Preliminary Acceptance Punchlist
El Paso County – Department of Public Works - Stormwater Section

Project Name:	Bent Grass Residential F2
EDARP Filing Number(s):	SF1914, CON2022
ESQCP Number:	ESQ228
Attendees:	DPW SW: Dylan Finley, Ben Jones DPW Development Services: Spencer Pirzadeh, Brad Walters Developer: George Hart, Erin Ganaway
Date of Walk-Thru:	09/13/2023
Walk-Thru Number:	1

WATER QUALITY
 DETENTION POND (POND
 WU)
 SF1914
 5/13/2020

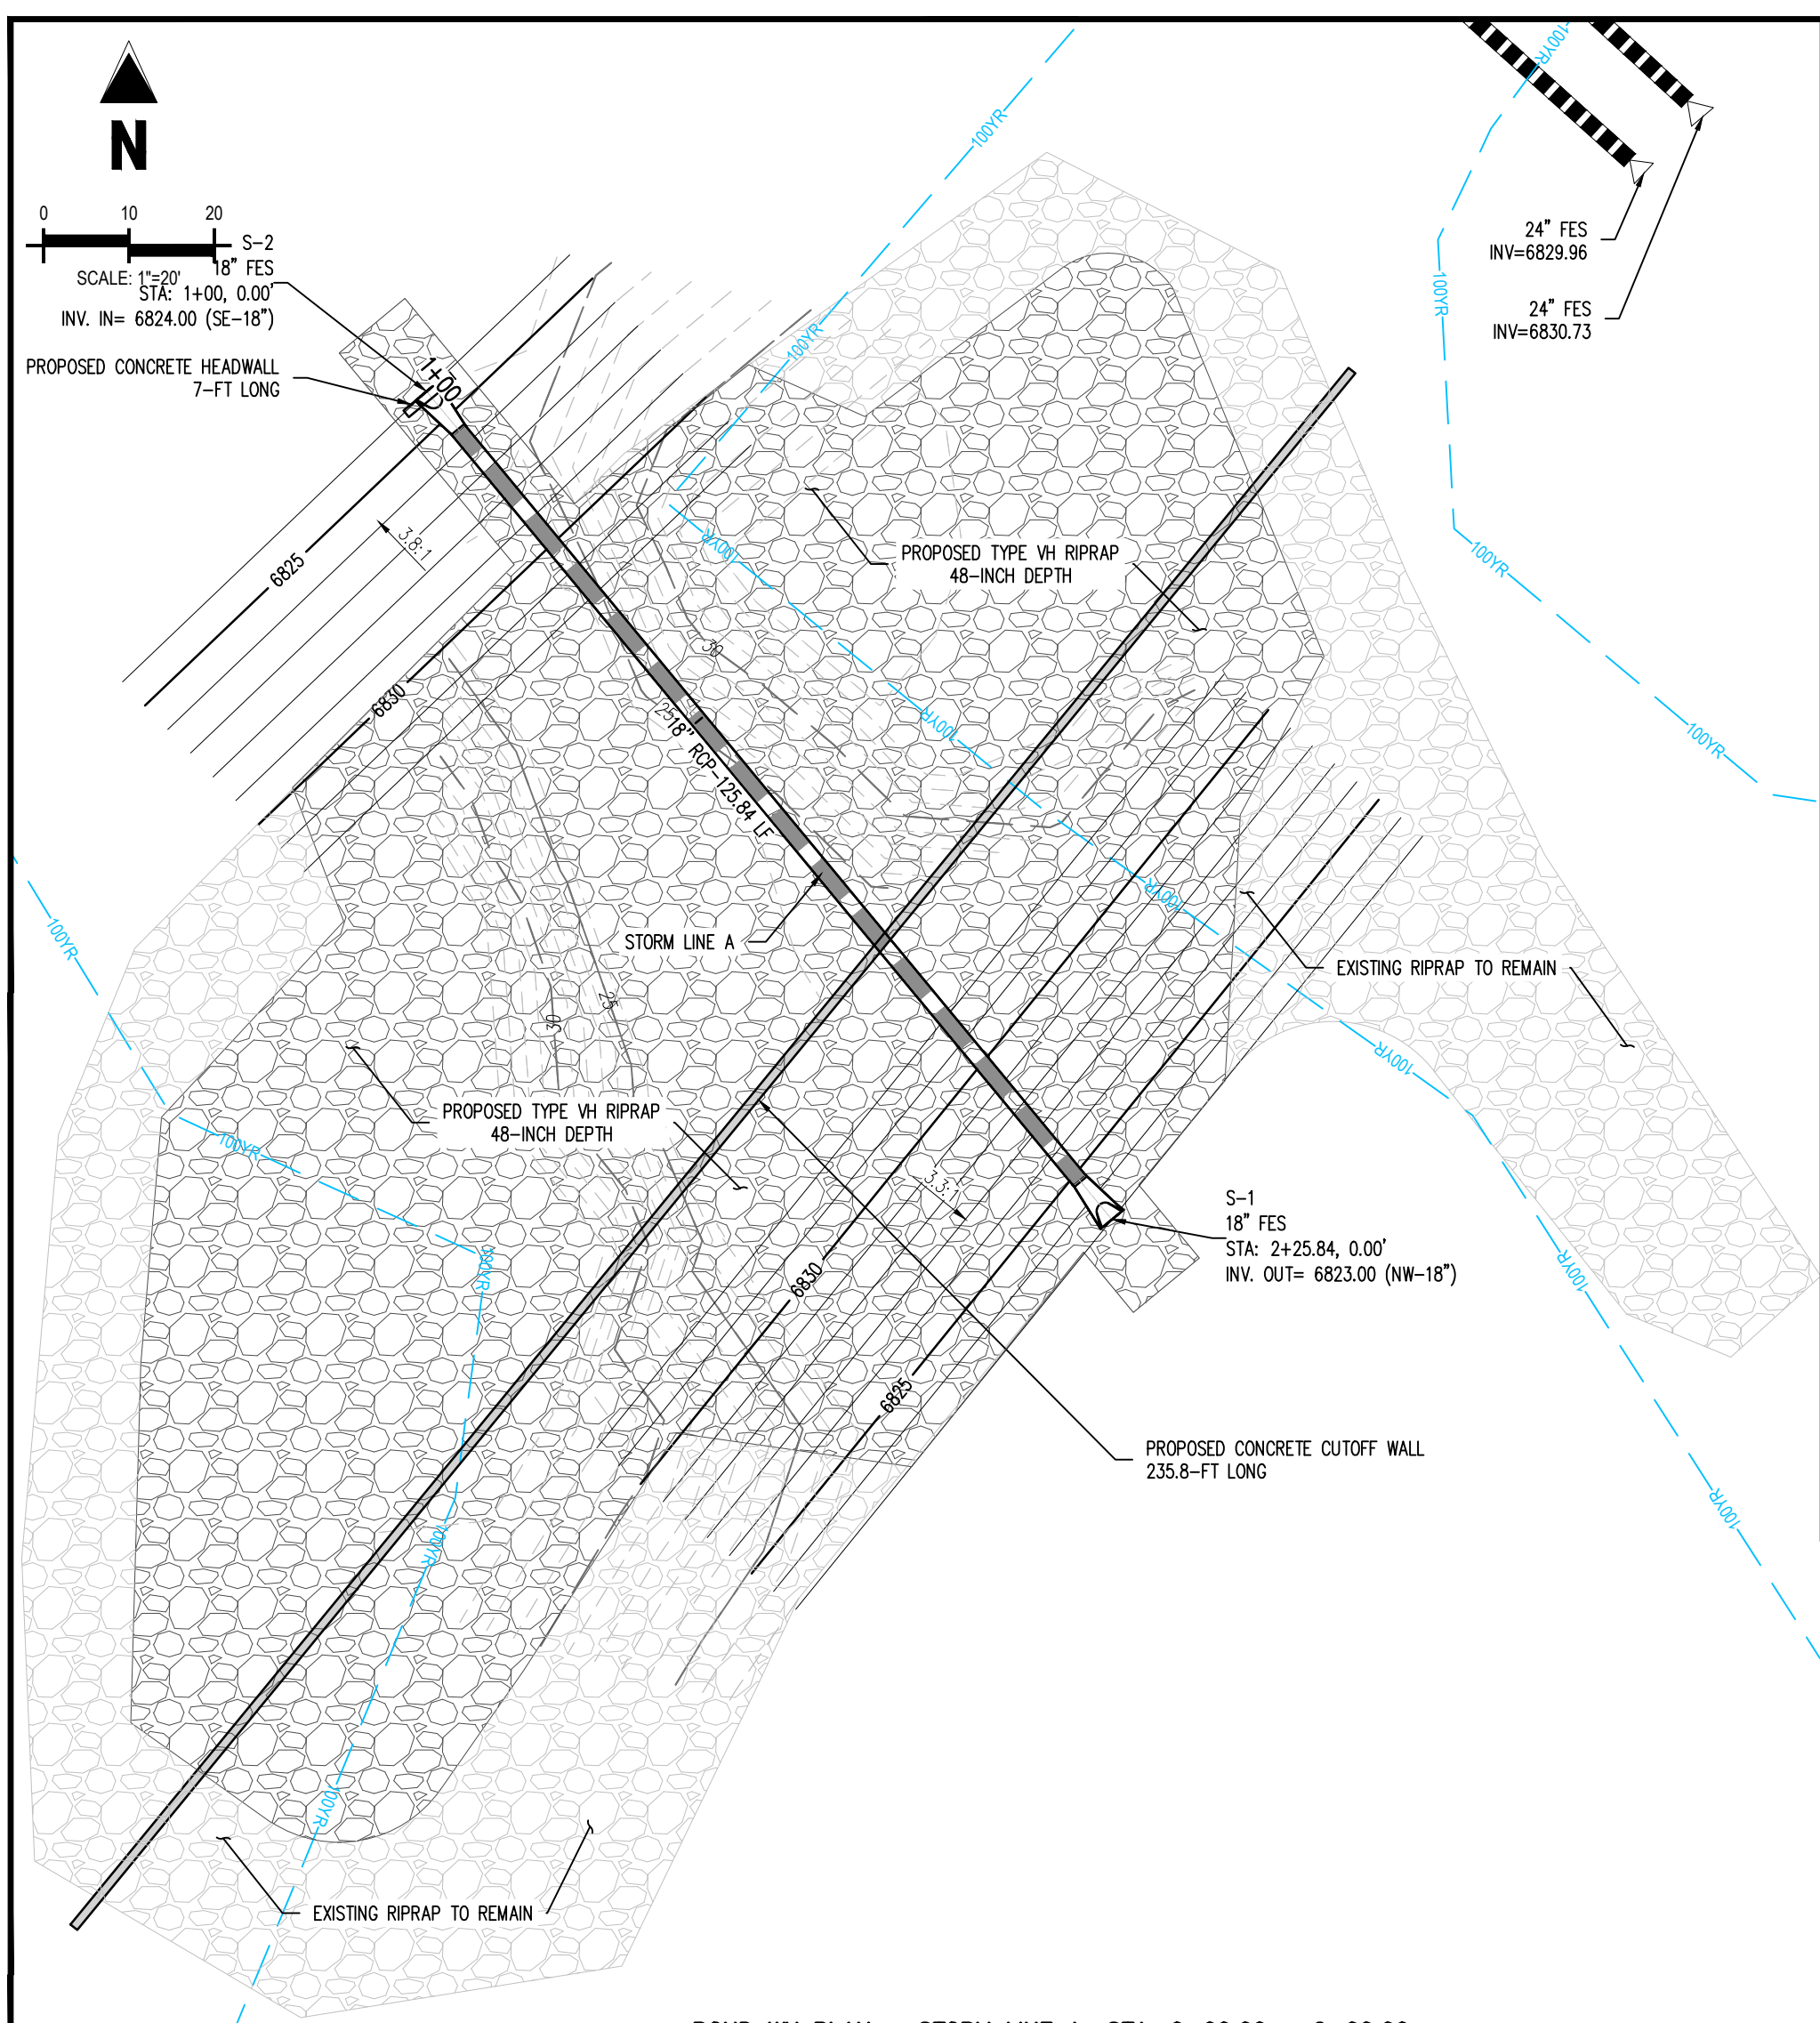
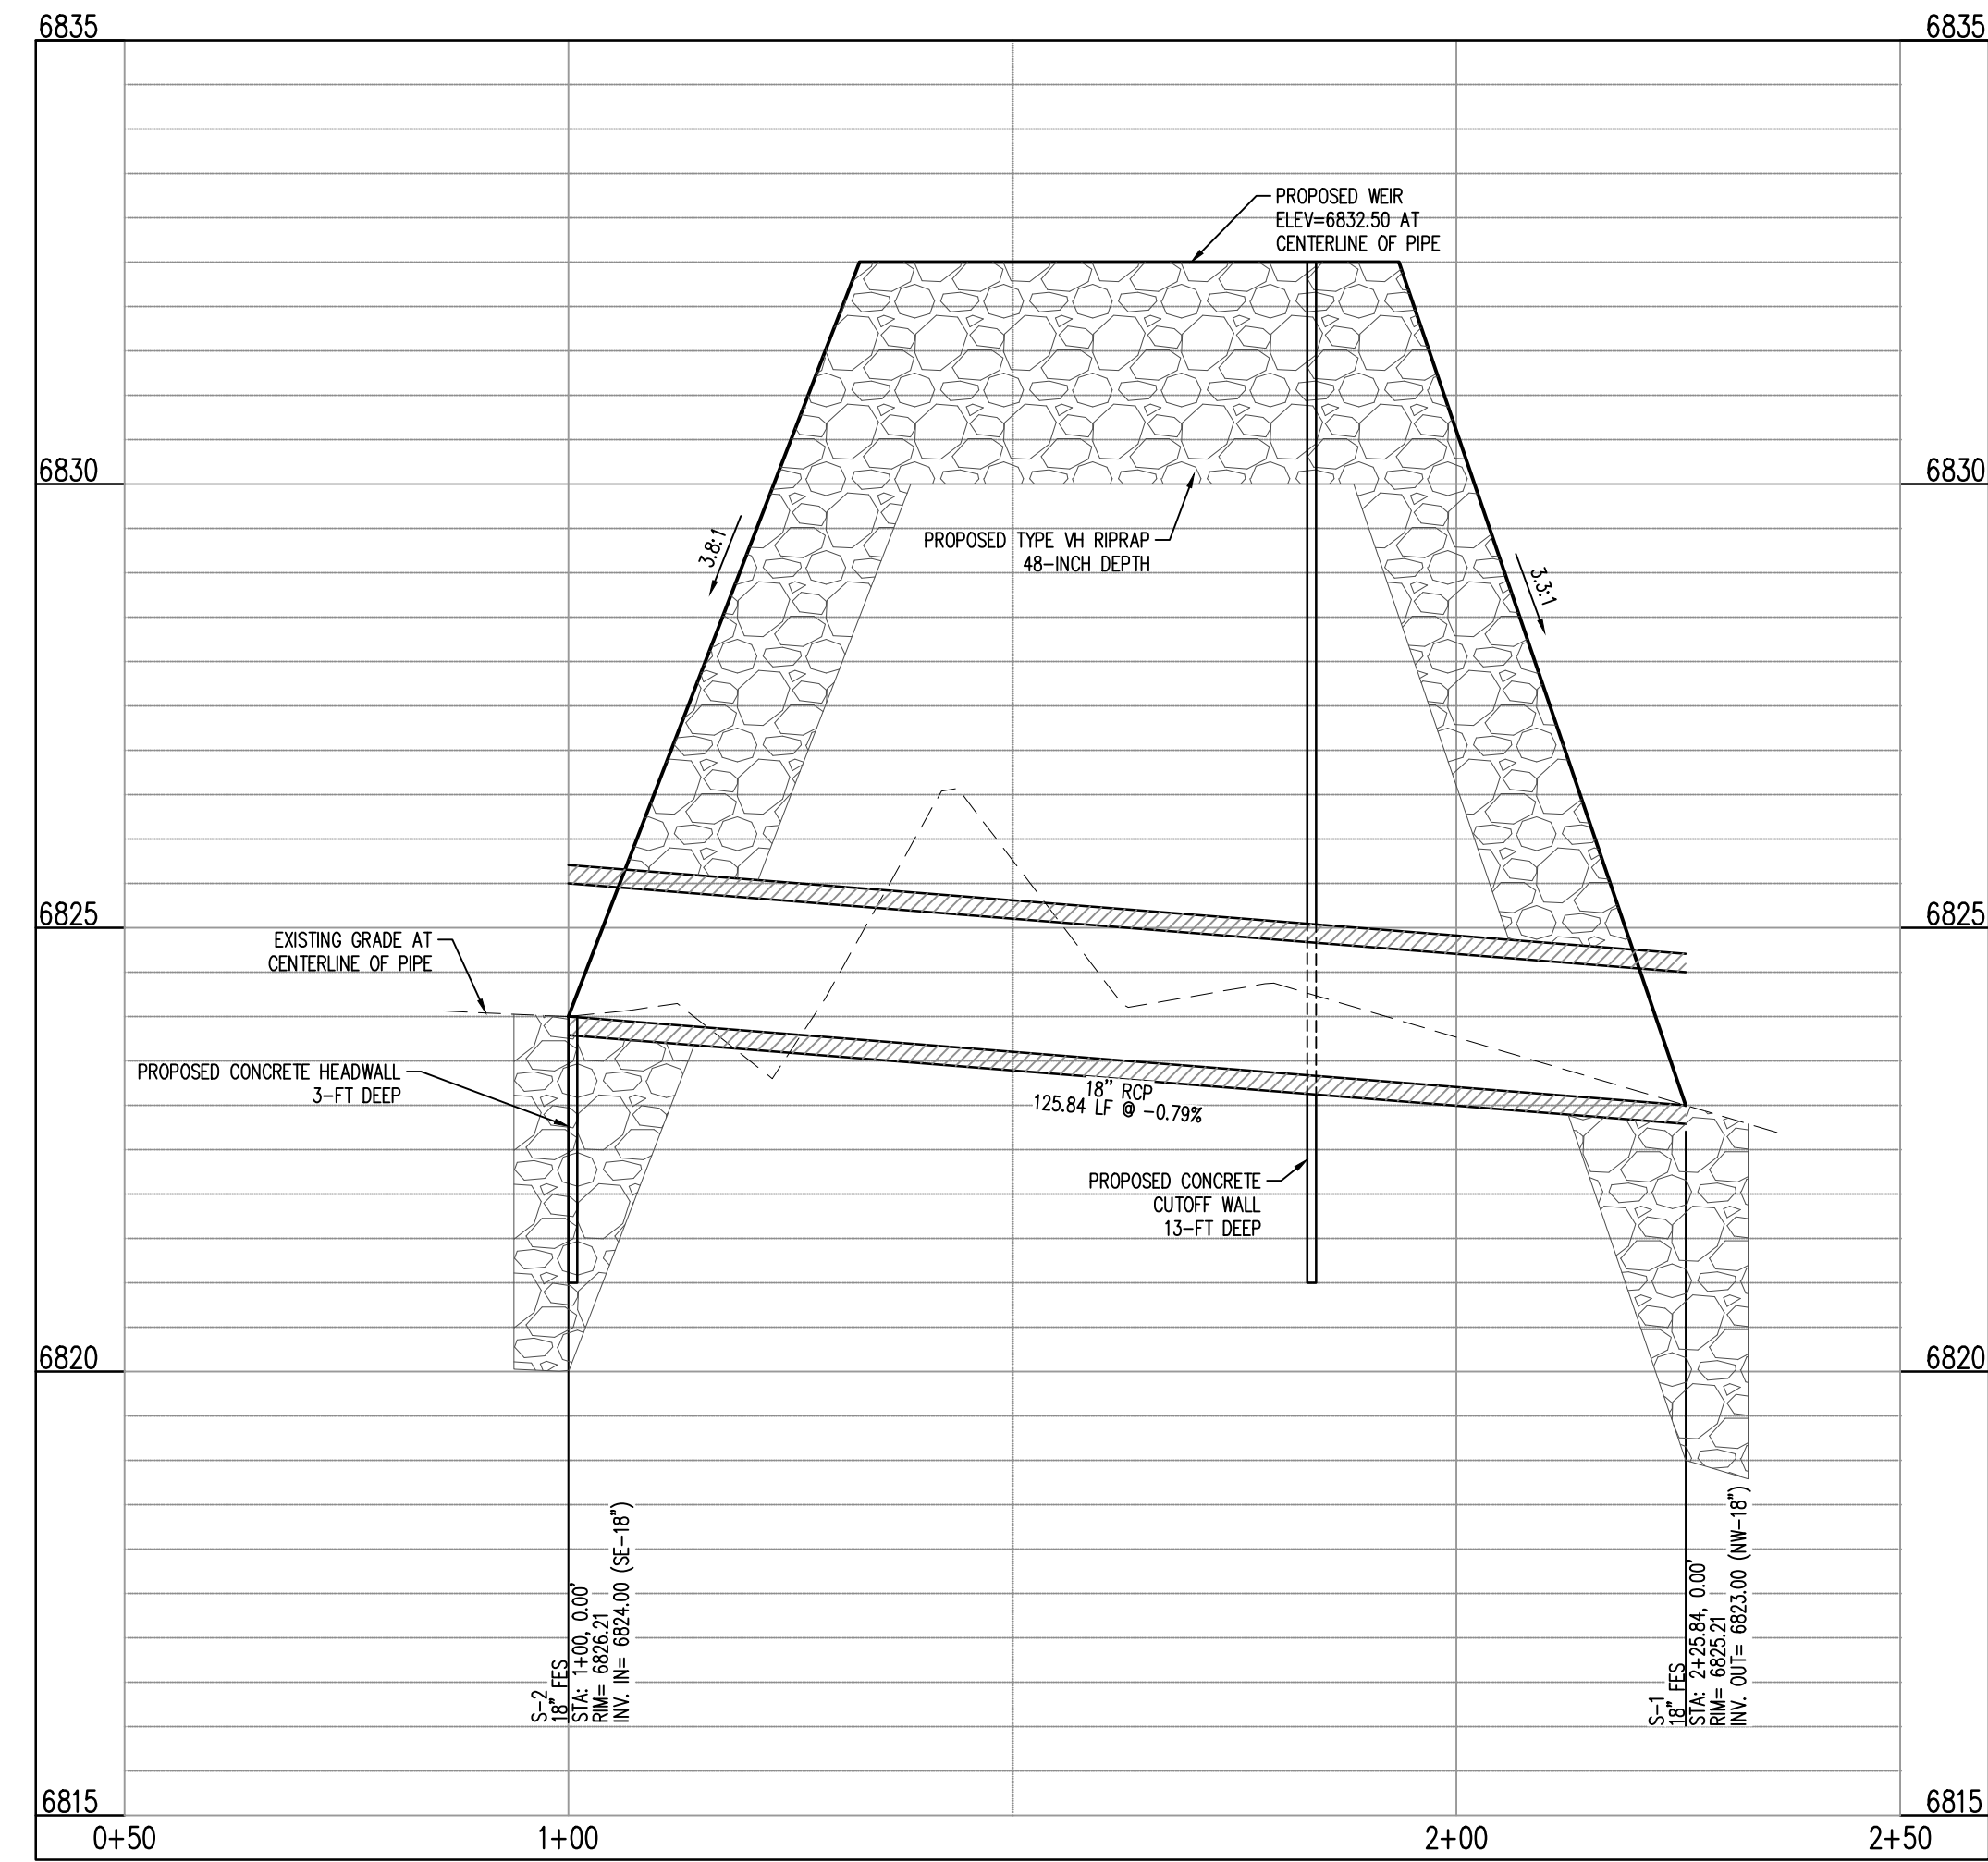
- Gaskets missing from all orifice plates. Install the watertight seal per specification.
- Install plate over cross member between trash rack and orifice plate to prevent debris clogging outlet structure.
